WEST SUSSEX COUNTY COUNCIL CONSULTATION

TO:	Arun District Council FAO: David Easton
FROM:	WSCC - Highways Authority
DATE:	15 March 2022
LOCATION:	Land at Bilsham Road Yapton
SUBJECT:	Y/15/22/DOC Approval of details reserved by condition imposed under Y/91/17/OUT relating to condition 25-Electric Vehicle Charging Strategy.
DATE OF SITE VISIT:	n/a
RECOMMENDATION:	More Information
S106 CONTRIBUTION TOTAL:	n/a

DRG No.
C0033_THAK_001

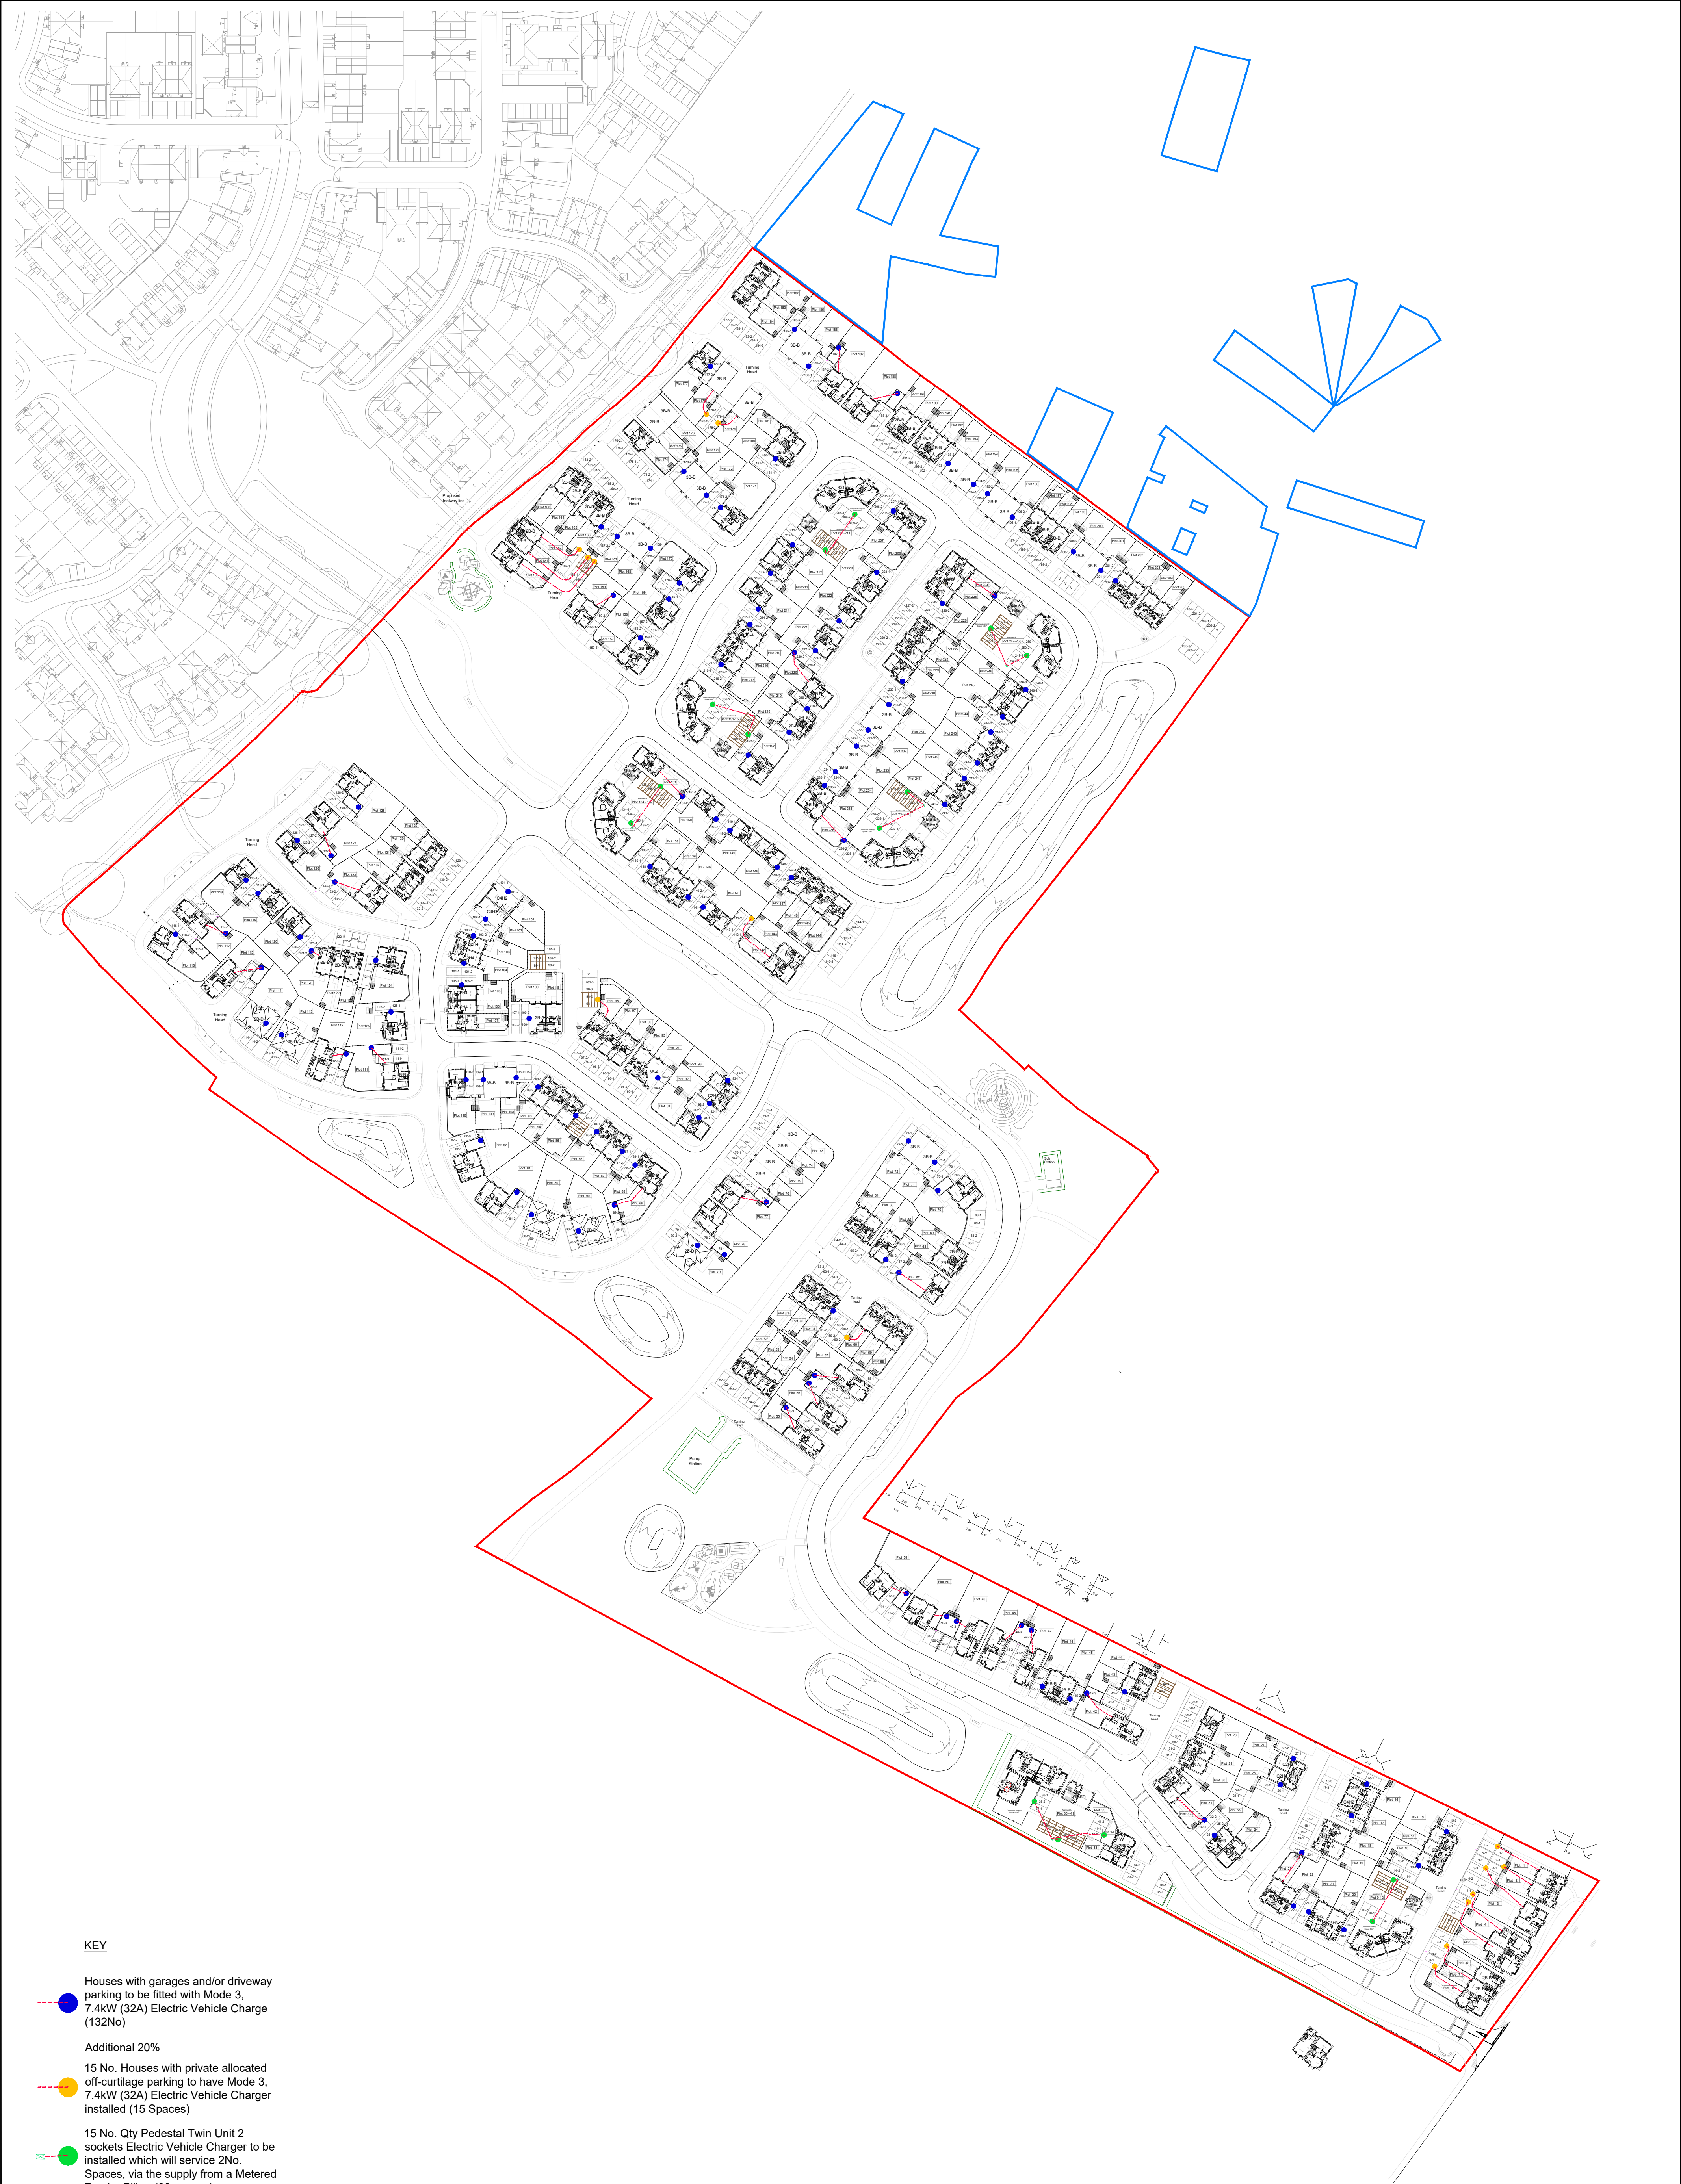
The Arun Parking Standards SPD requires that all new houses with a driveway or garage will be required to provide active EV charging points and all other development currently needs to provide EV charging points in 20% of the parking spaces. The applicant has submitted a plan detailing the EV charging provision across the site. This indicates that of the 250 properties proposed the applicant is providing 132 properties with a driveway or garage with an EV charging point. Of the remaining 118 properties an additional 45 EV charging spaces are to be provided. These shall be for 15 houses with private allocated off-curtilage parking and an additional 15 twin unit sockets which will each service 2 spaces. However, it is not apparent as to whether these 45 EV charging spaces for the remaining 118 properties equates to 20% of the total car parking provision; as is required by the SPD. The applicant should therefore clarify and demonstrate that level of provision equates to at least 20% of the car parking provision.

Given recent appeal decisions in the locality Arun District Council as Local Planning Authority should also ensure that the siting of EV charging points do not lead to any cables be located or crossing pedestrian through routes. This especially appears to be the case outside plots 3 to 8 where cables may trail over pedestrian routes.

Further information should be provided by the applicant to demonstrate compliance with the Parking Standards SPD.
